From: Willett Technical Service [REDACTED]
Sent: 02 December 2017 14:34
To: Charlotte Burrows
Cc: Jules Mob Pers
Subject: Re: Millhouse Croft attention Mrs C Burrows A/195/17/HH
Attachments: Front elevation design drw.pdf; nyse-barn-log-cabin photo .jpg; rear wall design drw.pdf; Side view section design drw.PDF; Side wall design drw.PDF; Side wall2 design drw.PDF

From: Charlotte Burrows <Charlotte.Burrows@arun.gov.uk>
Sent: 30 November 2017 13:59
To: [REDACTED]
Subject: RE: Millhouse Croft attention Mrs C Burrows A/195/17/HH

BLOCK/SITE PLAN
AREA 130m x 130m A3
SCALE 1:500
CENTRE COORDINATES: 508676, 103748

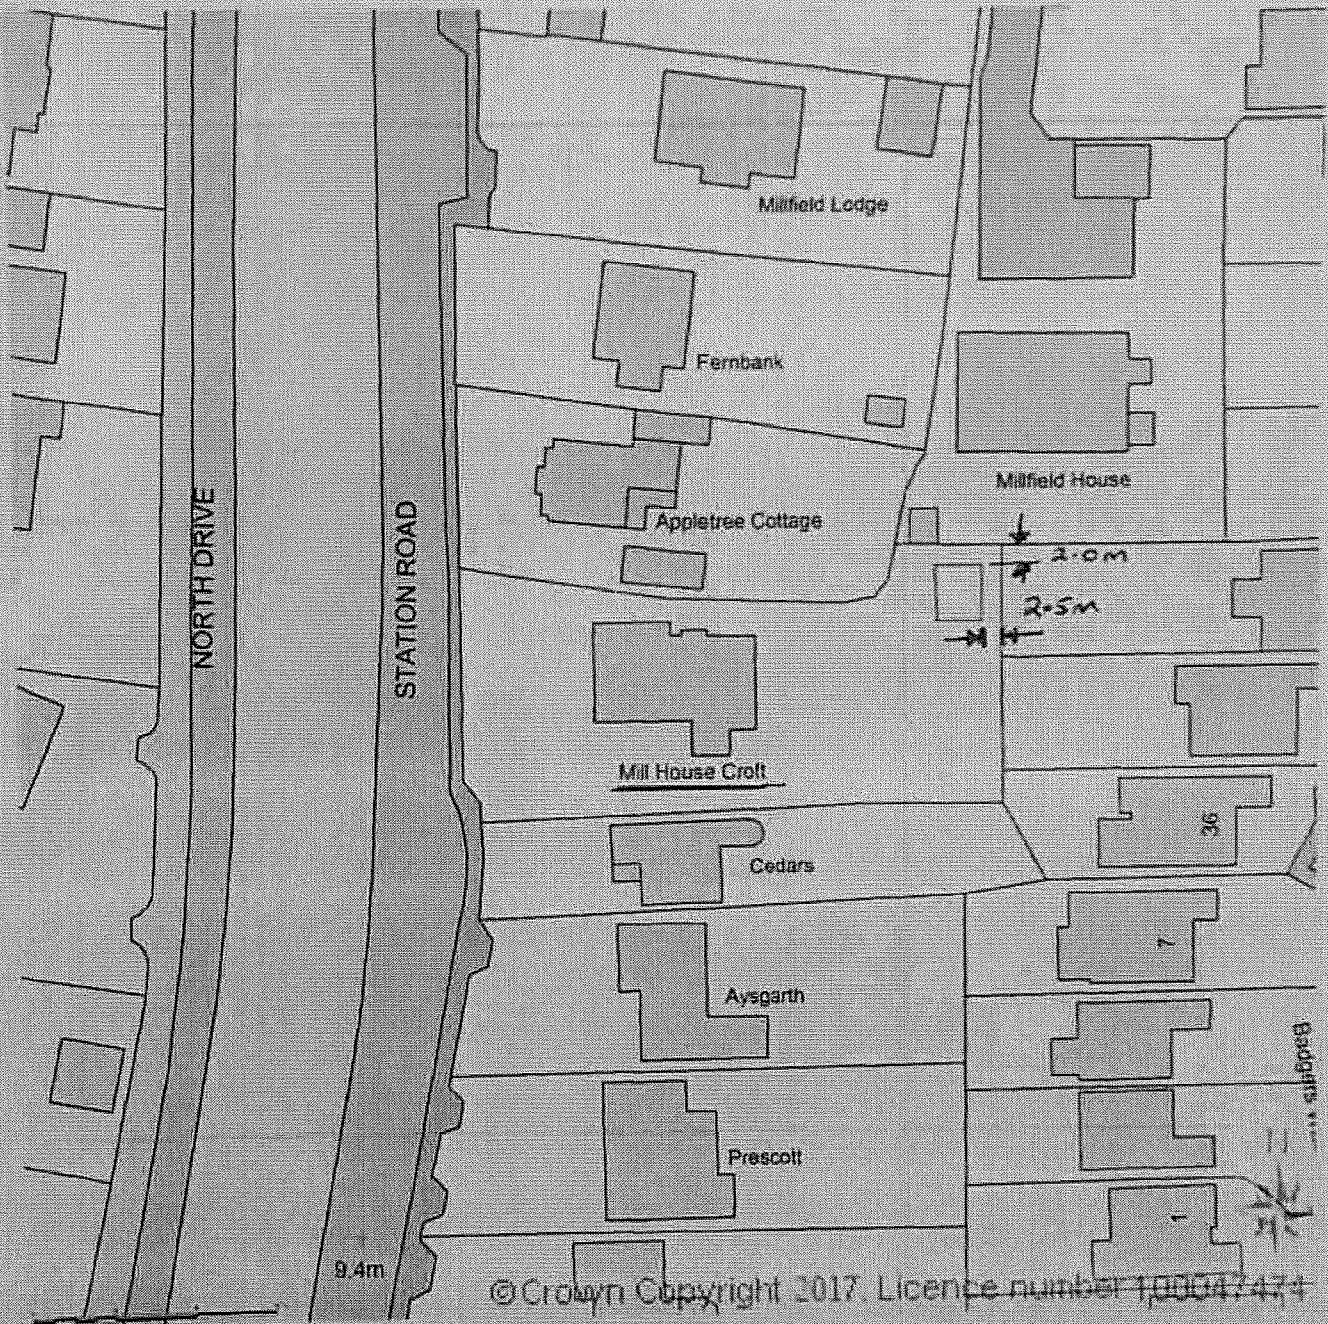
It is the Location plan we require and that should be at a scale of 1:1250 or for more rural sites 1:2500.

We require a Location plan, this would look similar to the submitted Block plan but would be at a scale of 1:1250.

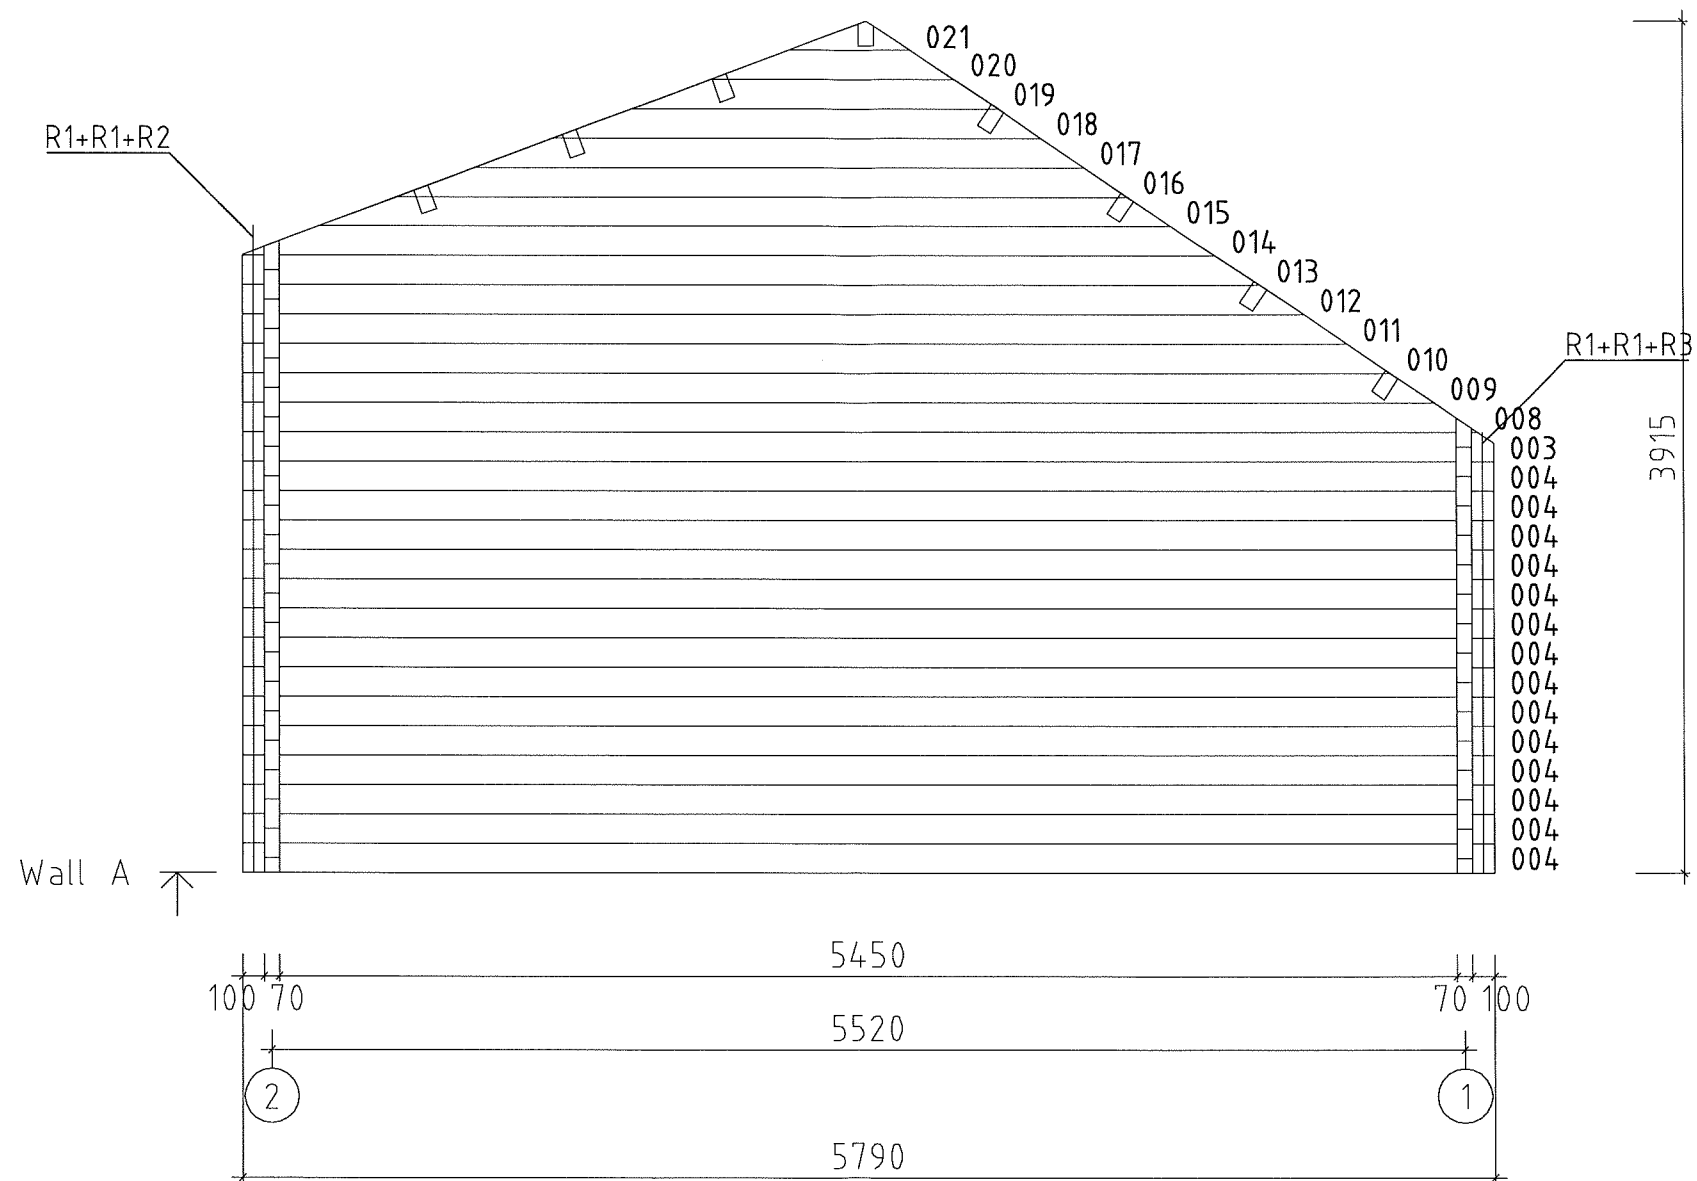
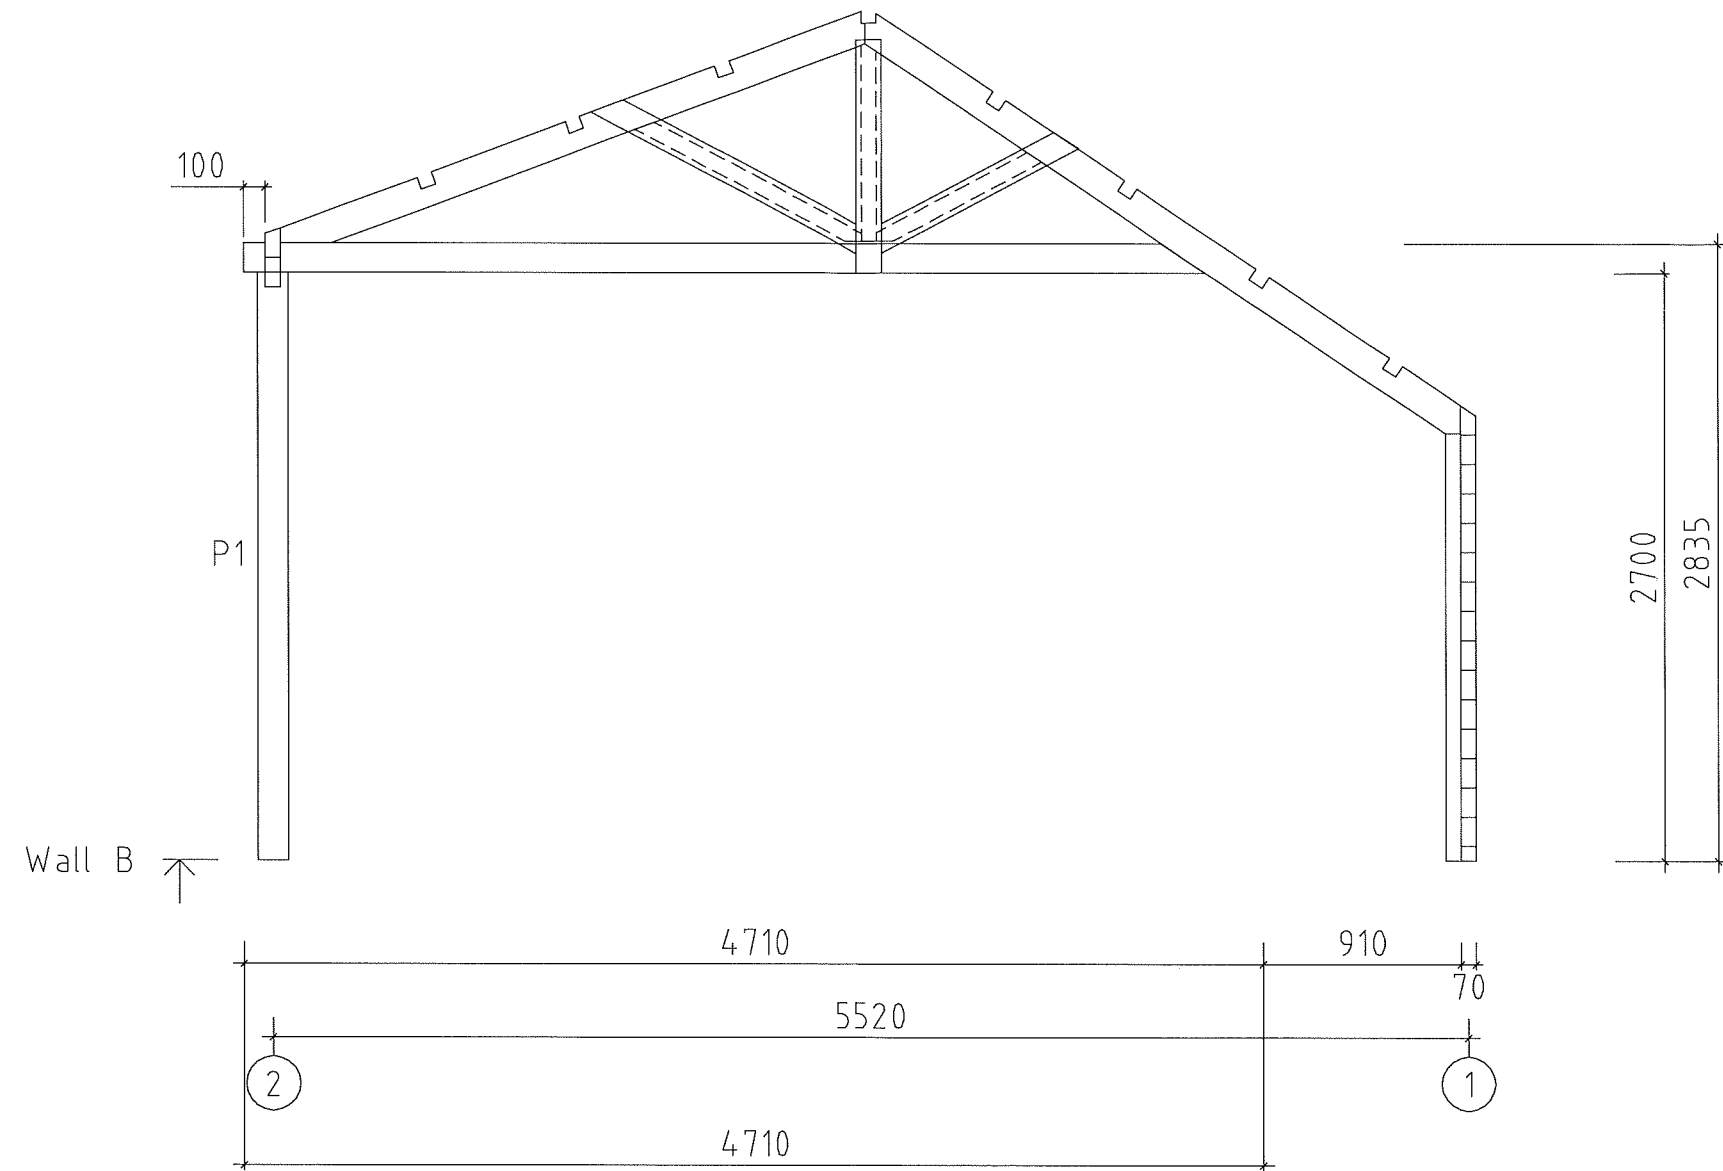
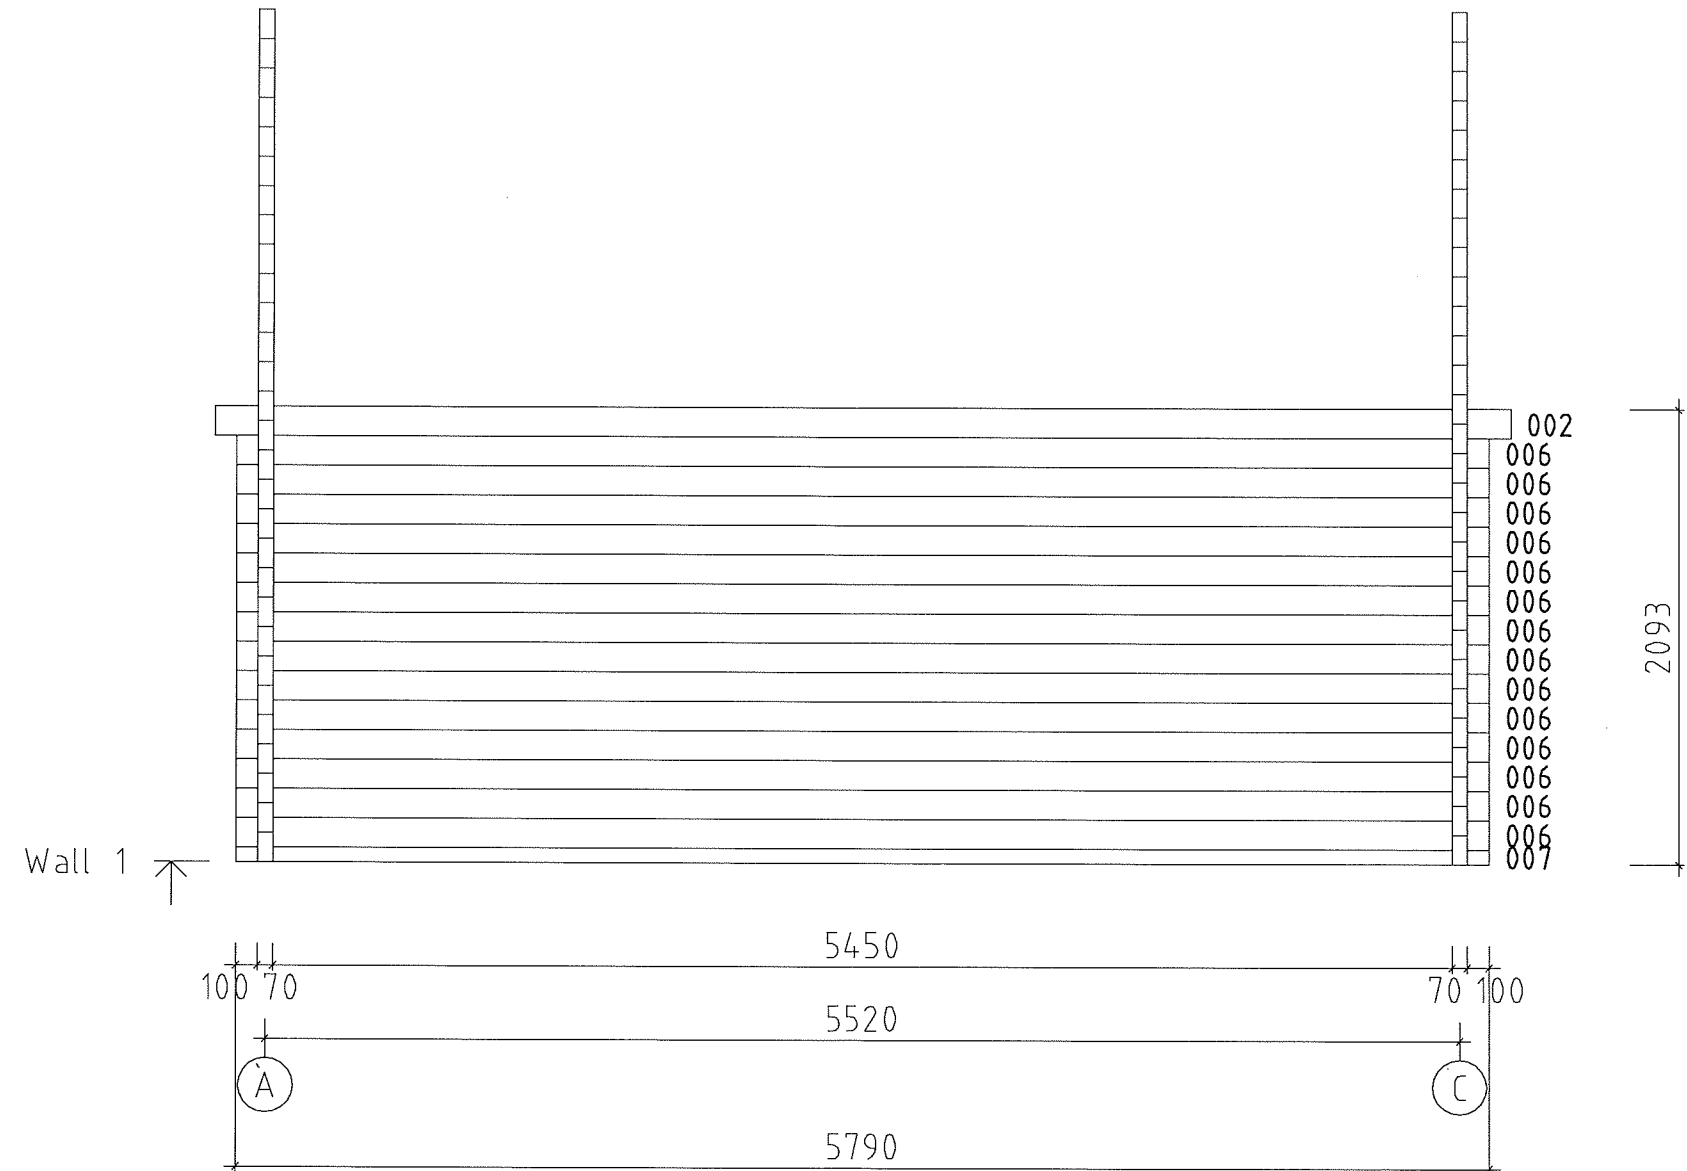
Also, with regard to your other email relating to the elevations. They seem to be called 'wall 1' or 'wall B' on the printed out plans, would it be helpful for me to post a hard copy back to you for you to amend by hand and return? If so please just let me know.

Also, we would ask you label the submitted elevations as to whether they are rear/side/front elevations.

The files above clearly show what the drawing is, ie "Front Elevation, rear wall, side view, side view 2 and side view section"
